Subject: AB/61/22/HH and AB/62/22/L - Conversion of loft to habitable use including installation of 3 x dormers and rear juliette balcony, addition of rendering, and alterations to fenestration/openings - Mews House, London Road Arundel.

The **Arun District Conservation Area Advisory Panel** wish to make the following comments in respect of the AB/61/22/HH and AB/62/22/L:

PROPOSED PLAN NEW ATTIC LIVING AREA

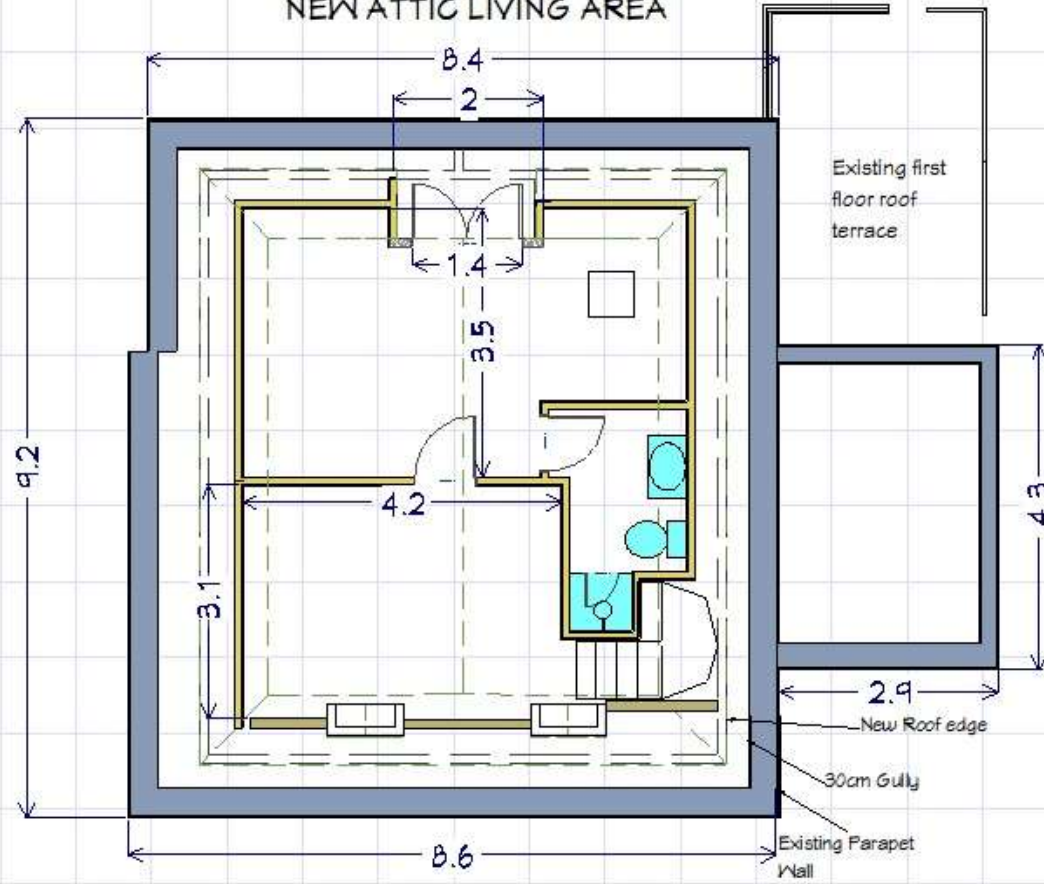
The Panel's opinion is that the intended new 'mansard' roof will be too high and dominant and is unsympathetic with the particular design, style and historical background of the property. The proposals will alter the scale and nature of the building, detracting from its heritage significance as an historical ancillary and visually subservient structure to Tower House. As such, the proposed alteration will also impact adversely on the heritage significance of both buildings, the character and appearance of the conservation area and the settings of extremely important and significant listed buildings nearby, all located in a townscape of national importance.

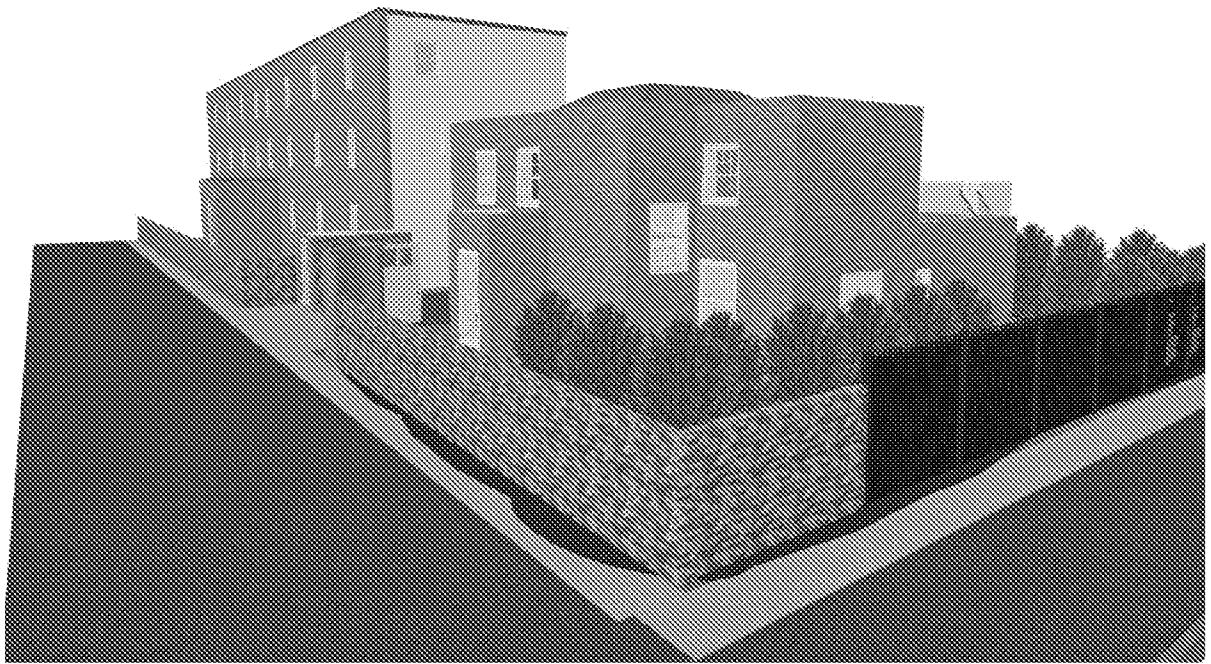
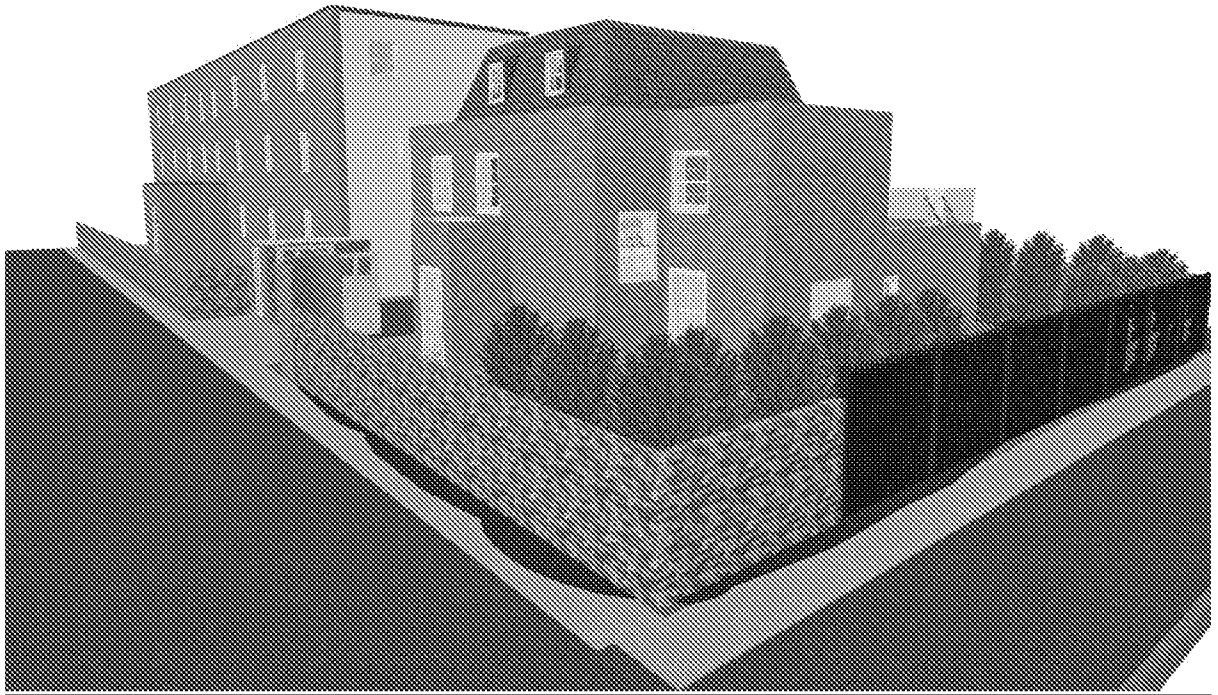
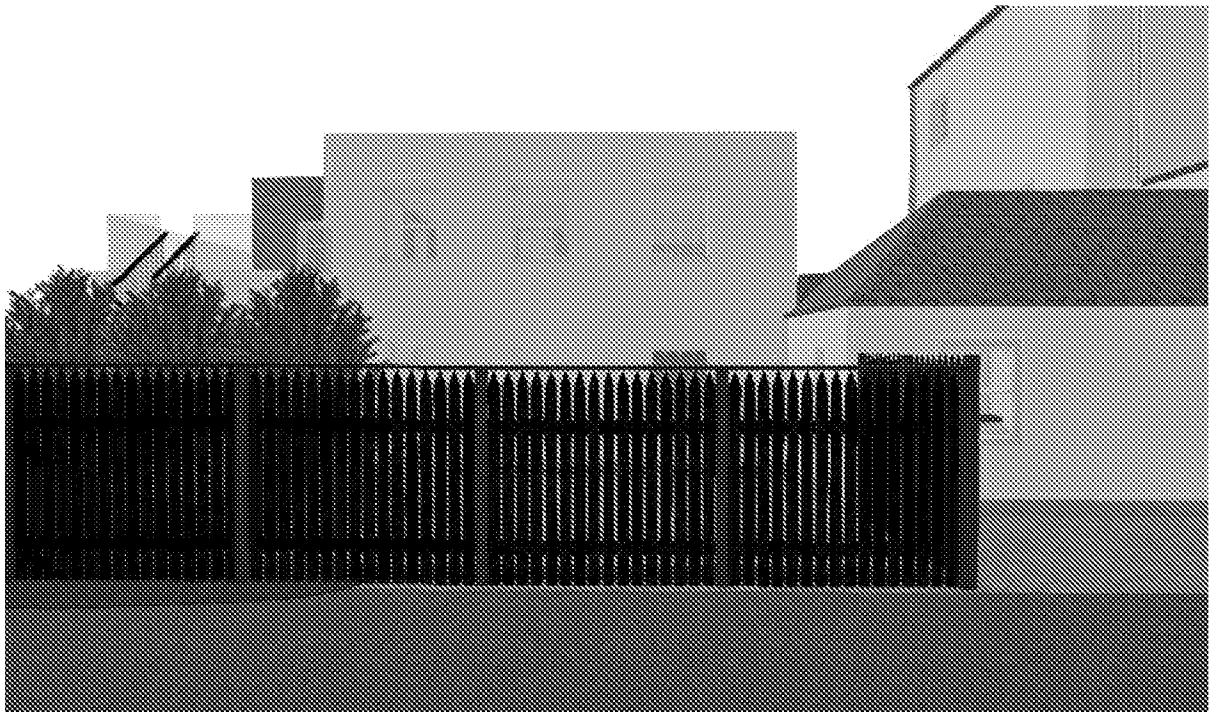
Surely, accurate and detailed drawings of the elevations (existing and proposed) should have been submitted, with the computer illustrations acting as supporting information. This is particularly important given the sensitive and important heritage context. The Heritage Statement does not appear to address in any detail the impact of the proposal on the designated and non-designated heritage assets in the locality. More historical information is also required.

As indicated before what would significantly improve the appearance of the building is not more additions but the replacement of the current pvcu windows on the street elevation with painted timber vertically sliding sash windows.
